KITTITAS COUNTY

MEMORANDUM

SUBJECT: Mitchell Short Plat SP-17-00003 *3*

NANEUM ROAD SHORT PLAT  
 PART OF SECTION 33, T. 18 N., R. 19 E., W.M.  
 KITTITAS COUNTY, WASHINGTON

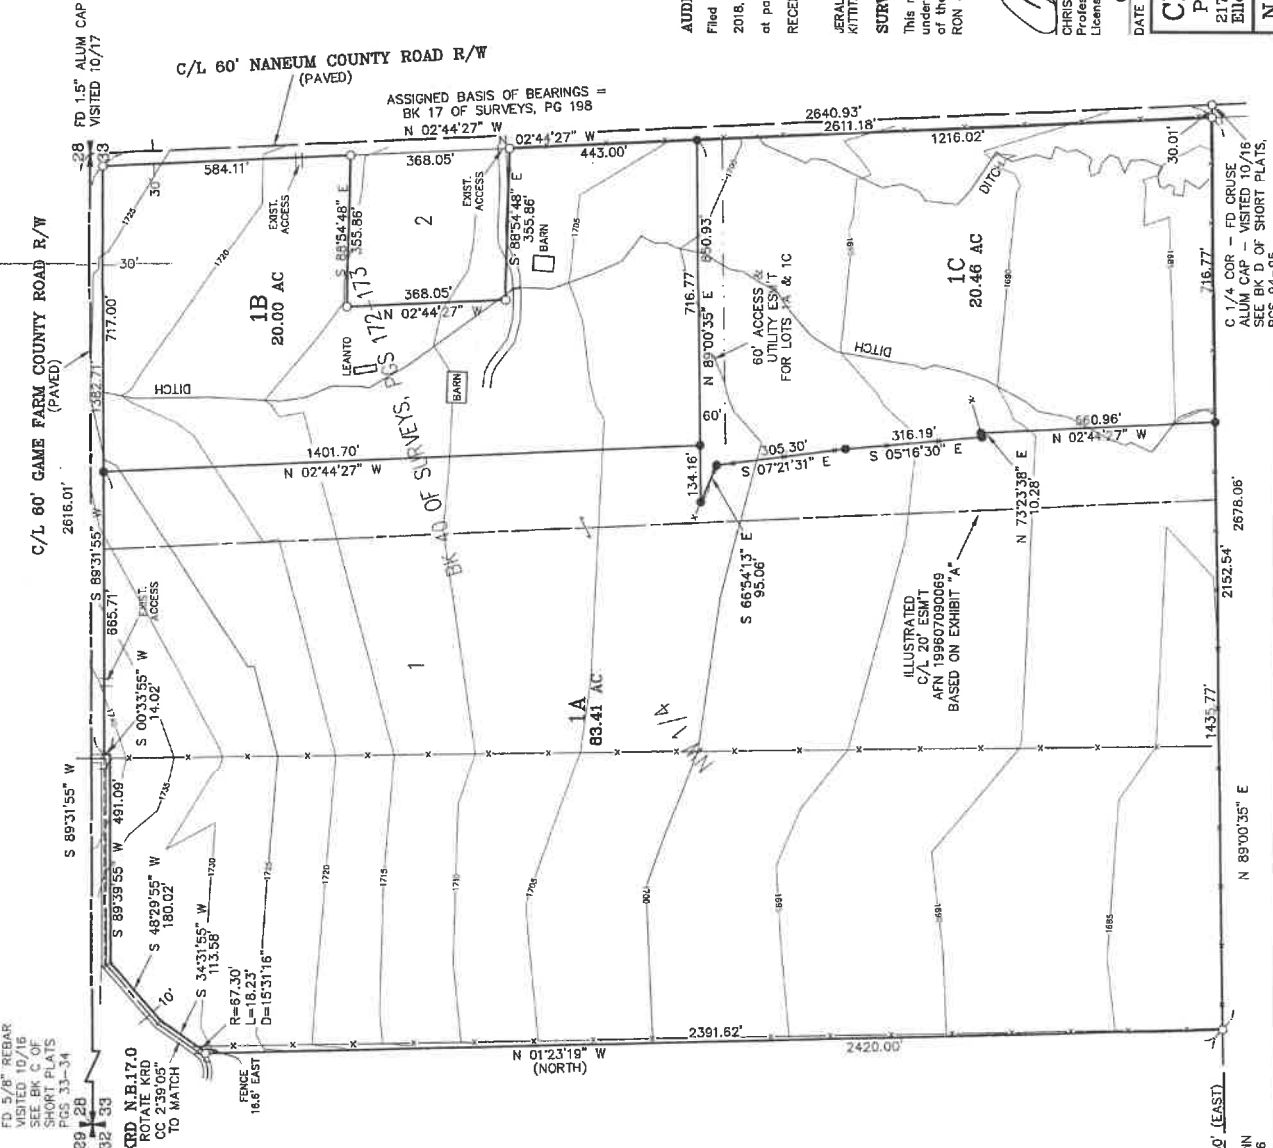
1. Access to Lot 1B: A 30' Joint Access easement for lot 1B and tax parcel 30936 to be shown on the face of the short plat.
2. Driveways: A driveway shall serve no more than two tax parcels. See Kittitas County Road Standards, 12/15/15 edition.
